**From:** Michael Eastham <Michael.Eastham@arun.gov.uk>  
**Sent:** 20 April 2021 13:57  
**To:** Planning.Responses <Planning.Responses@arun.gov.uk>  
**Subject:** FW: Y/131/20/DOC - Condition 8 - Land South of Ford Lane and East of North End Road, Yapton

Please upload onto Ocella the email below which is a final consultation response from the **Local Highway Authority** raising **"No objection"** to **Condition 8** of discharge of condition application **Y/131/20/DOC**.

**From:** Tim Townsend [REDACTED]  
**Sent:** 20 April 2021 13:33  
**To:** Dominic Smith [REDACTED] Michael Eastham <Michael.Eastham@arun.gov.uk>  
**Cc:** Tilly Wishaw [REDACTED] Lee Moses [REDACTED]  
**Subject:** RE: Y/131/20/DOC - Condition 8 - Land South of Ford Lane and East of North End Road, Yapton

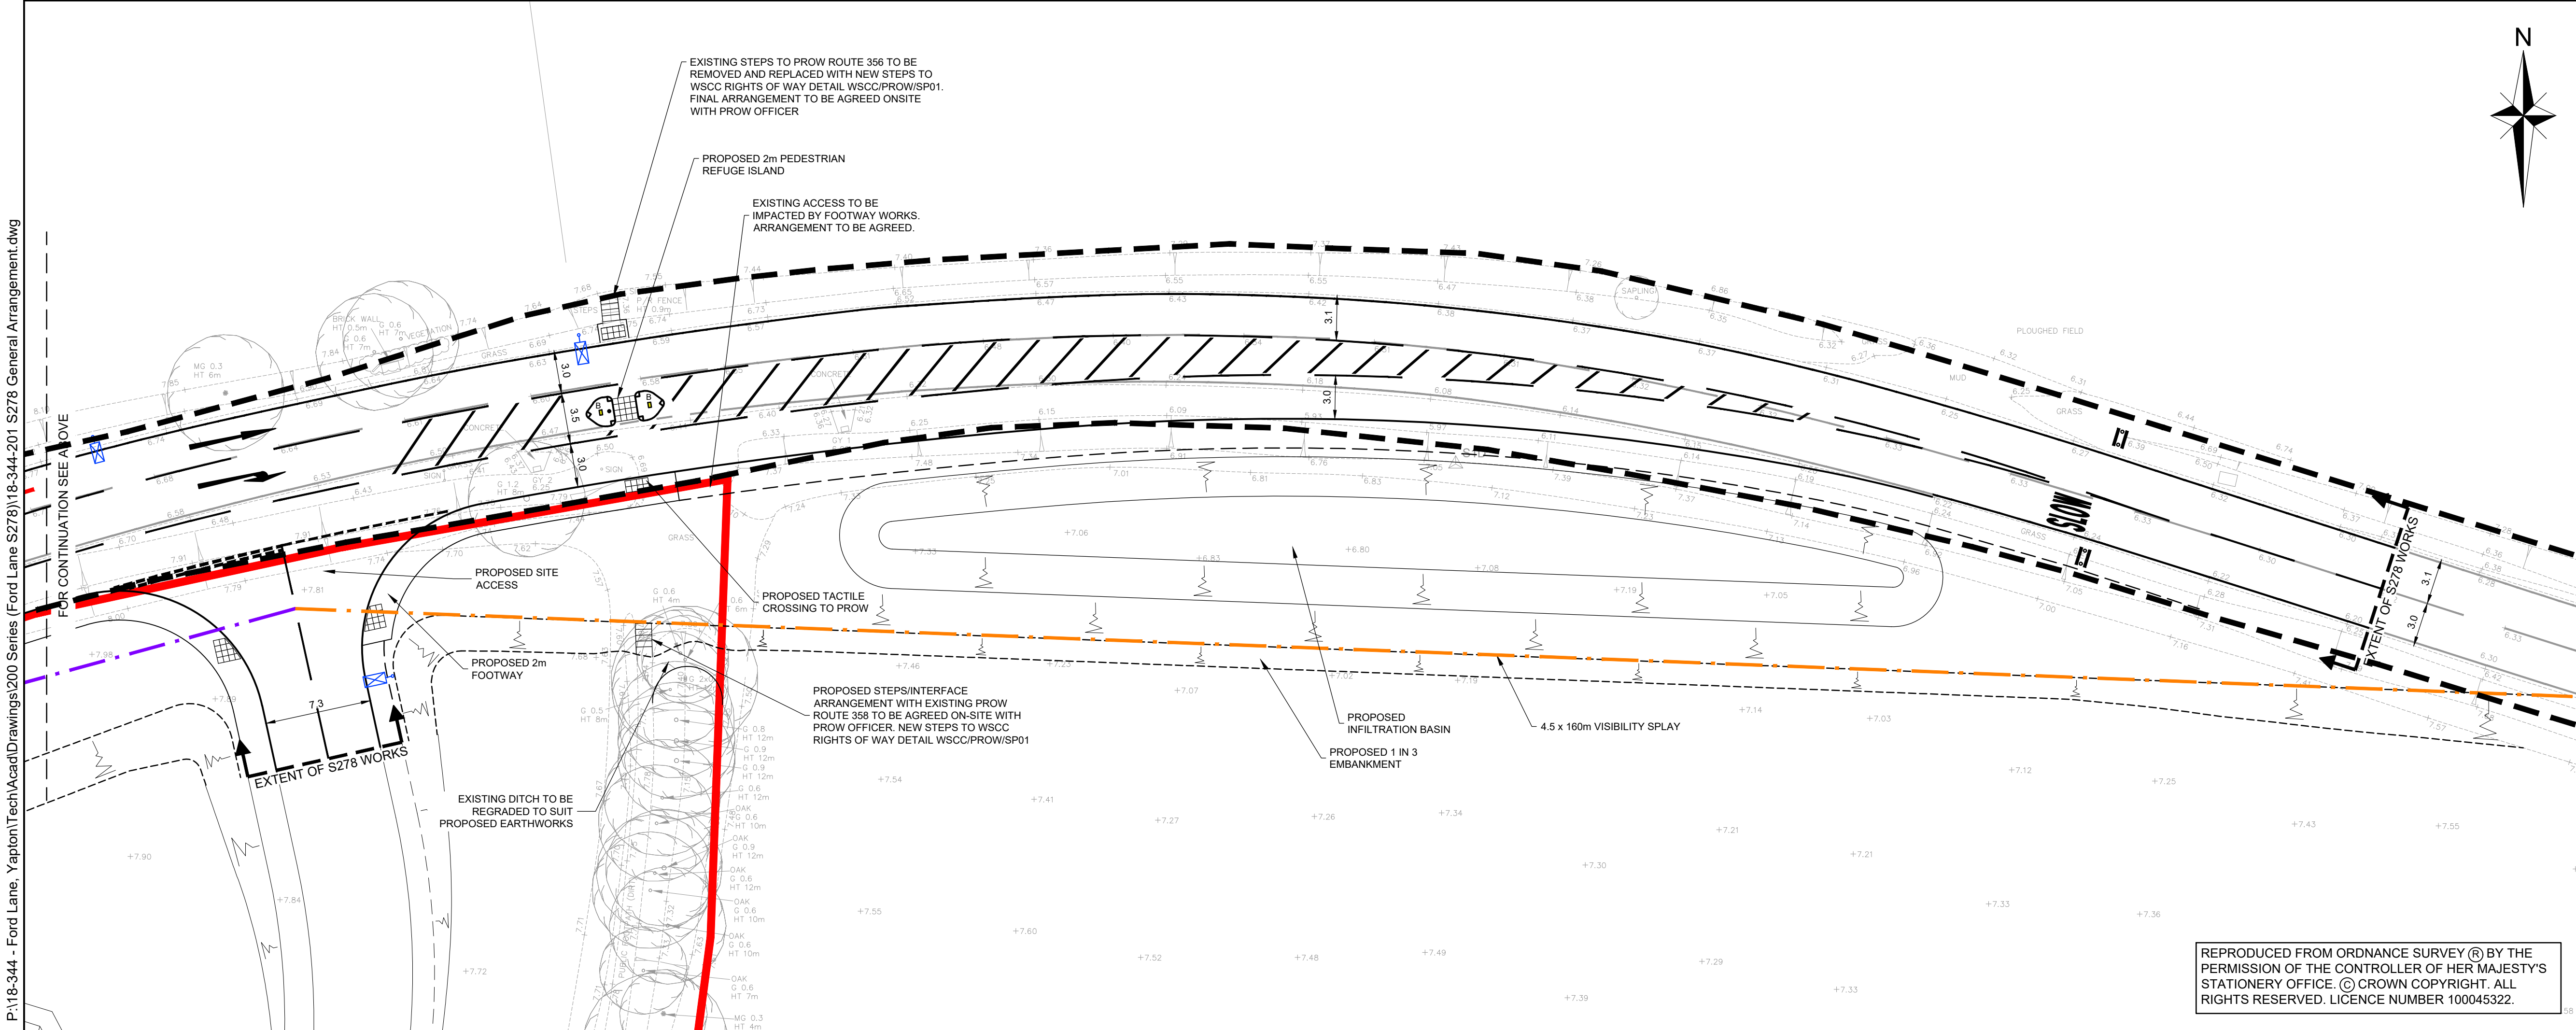
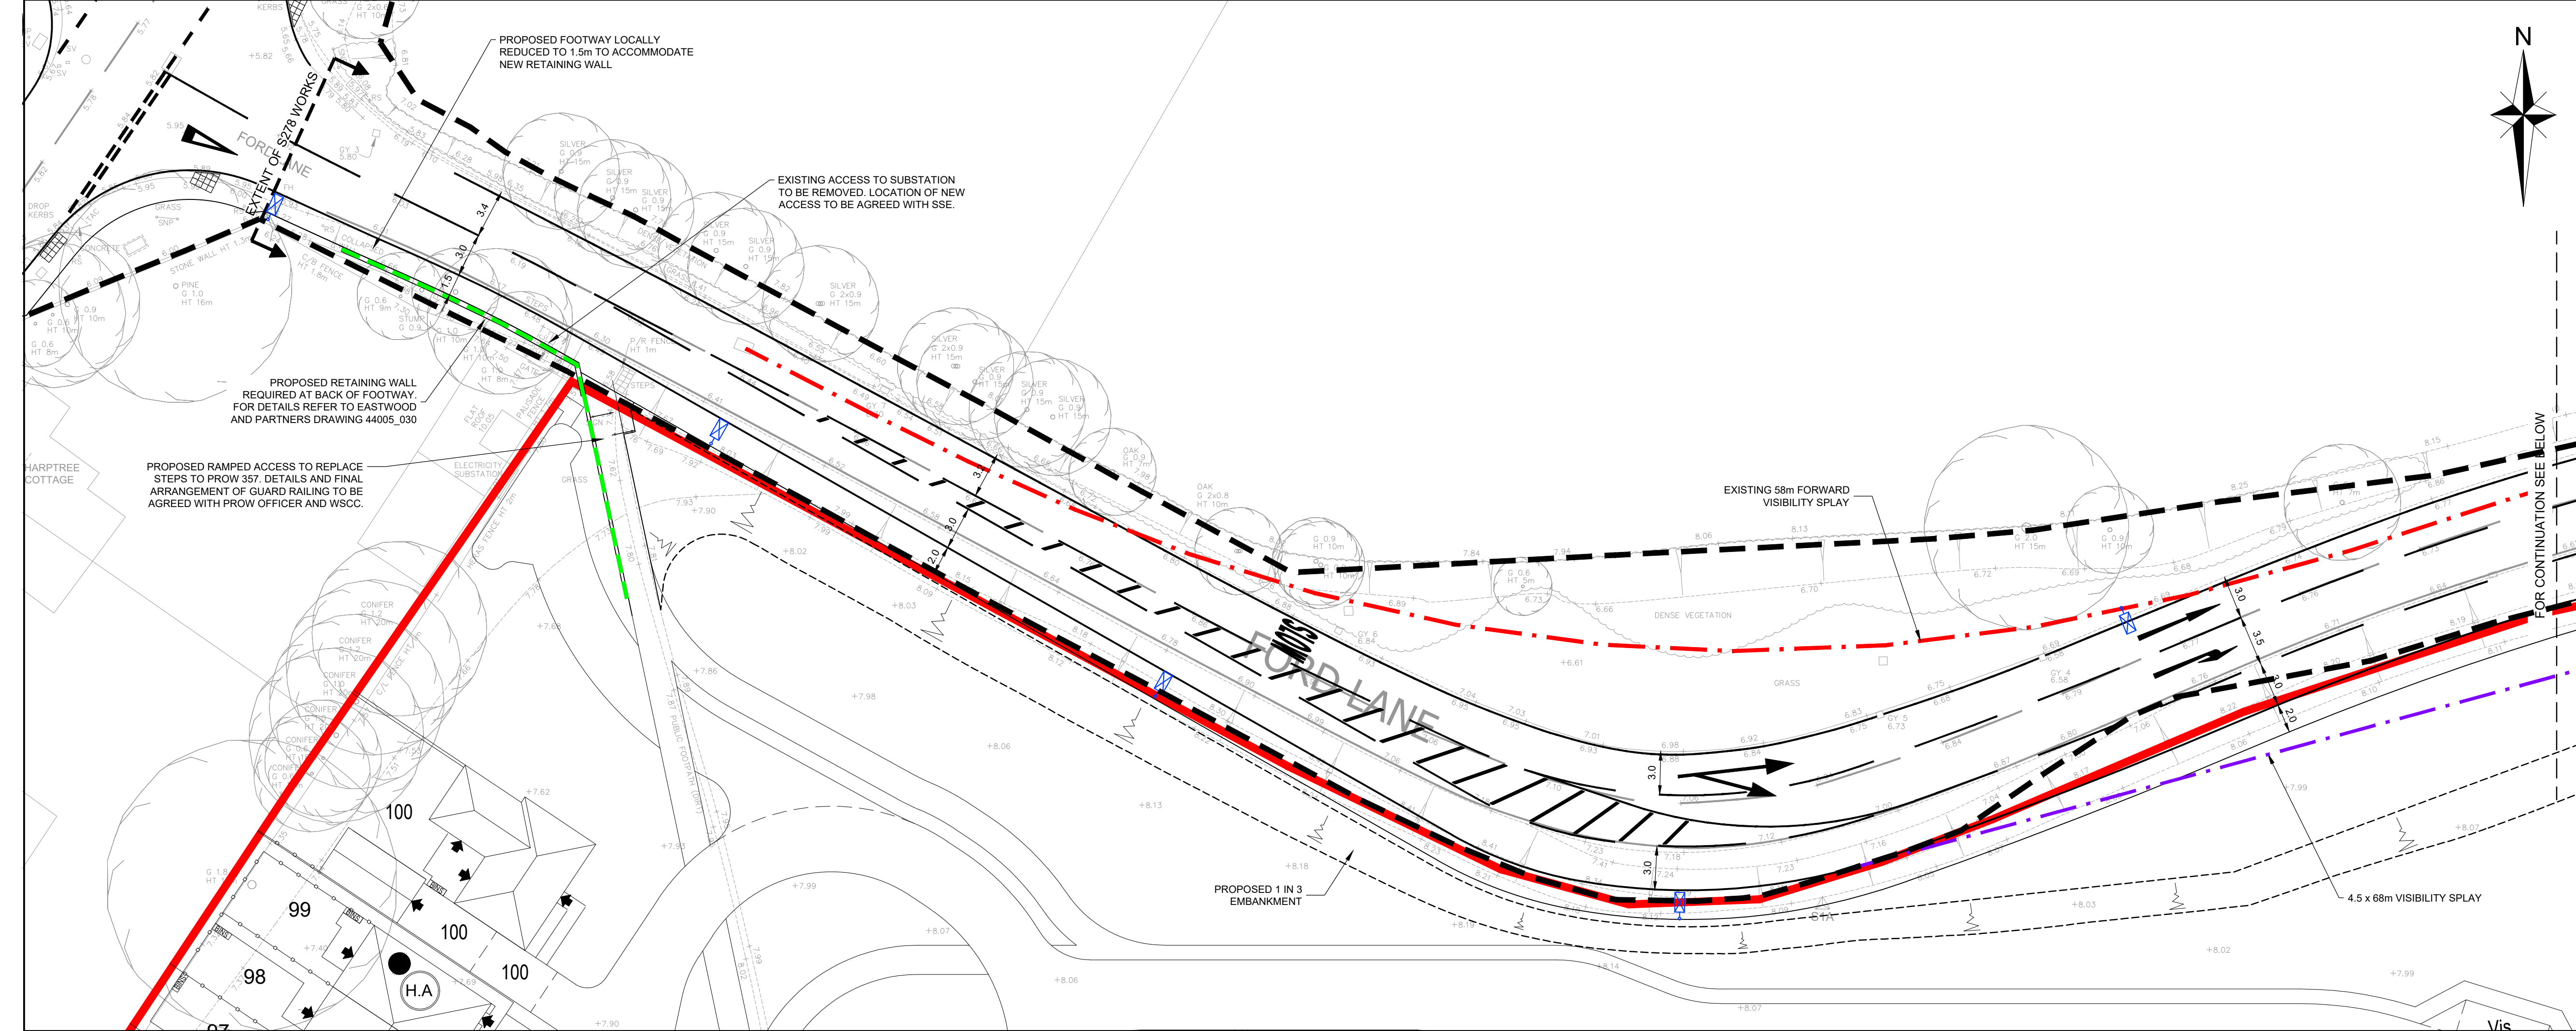
From the WSCC Highways perspective, I am happy to proceed on the basis of the information provided below. However, I will add that at the construction stage, it will be important to ensure that the path in and out of the site is as level as possible in order to avoid any steep slope from the site boundary to the edge of the North End Road. As such, careful grading of all approaches to the said feature will be required and also appreciating also that some of the works will require some changes to the already approved S278 works also on North End Road.

We've received comment back from the Auditor which recommended one further amendment – the barriers be reinstated to replace the bollard. I've spoken to Tim; the WSCC preference would be for the bollard, and prior to installation the specification of the restraint measure (whether it's a barrier or a bollard) can be considered through an Exception Report. For the purposes of the drawing we've shown a barrier with a note.

- 1. Problem B.2.1** – It is my understanding that the steps currently providing pedestrian access to Ford Lane at the northern end of Public Footpath 357 and referred to in the Safety Audit are to be removed and replaced by a ramp as part of the S278 works for Ford Lane. Please would you check this and if correct, refer to the Audit Team for any further comments. Following that, you will need to re-visit the Designer's Response in light of the ramp (if confirmed) and any comments forthcoming from the Audit Team.
- 2. Problem B.4.2** – Although the Designer's Response refers to provision of tactile and corduroy paving it does not reply to the Audit Team's comments about lack of facility to permit cyclists to enter or leave North End Road on the 'level'. As such, this needs to be addressed, please, and the Designer's Response updated accordingly.

- Drawing ITB14679-GA-002 Rev G – PROW Plan
- ITB14679-006D – GG119 Appendix F Form, prepared by i-Transport LLP
- Road Safety Audit Report: Proposed works to existing Public Footpaths through Meadow Gardens, North End Road, Yapton (Ref. RSA-20-193 Issue 3), prepared by Fenley Road Safety Limited
- 310321 – Additional Auditor Comments 1
- 200421 – Additional Auditor Comments 2

Please find attached the amended drawing – ITB14679-GA-002 Rev F. There has been a slight tweak to the arrangement for the access onto Ford Lane, which includes replacement of the staggered barrier with a bollard and the introduction of tactile paving and give-way demarcation.

I've added both your comments and the Design Team response to the Appendix F record. We've reinstated the footway to a 3m width, given that the identified hazard won't be present with the change to a slope. The slope itself forms part of the S278 Highway Works, which I understand have received consent, and so the safety of this feature will have been considered as part of this approval process. Nevertheless, I've sought confirmation from the Auditor that they are satisfied with the proposed amendment and I'll forward this as soon as I have it.

In respect of the transition to the North End Road carriageway, this is again outside of the scope of the Audit and is situated in the area covered by the S278 Agreement. Notwithstanding, we've identified that dropped kerbs can be provided at this location to provide the transition that you seek – as these would be constructed in accordance with WSCC Standard Details, I envisage that they can be incorporated as a change into the construction and recorded as part of the S278 Agreement as part of the as-built drawings.
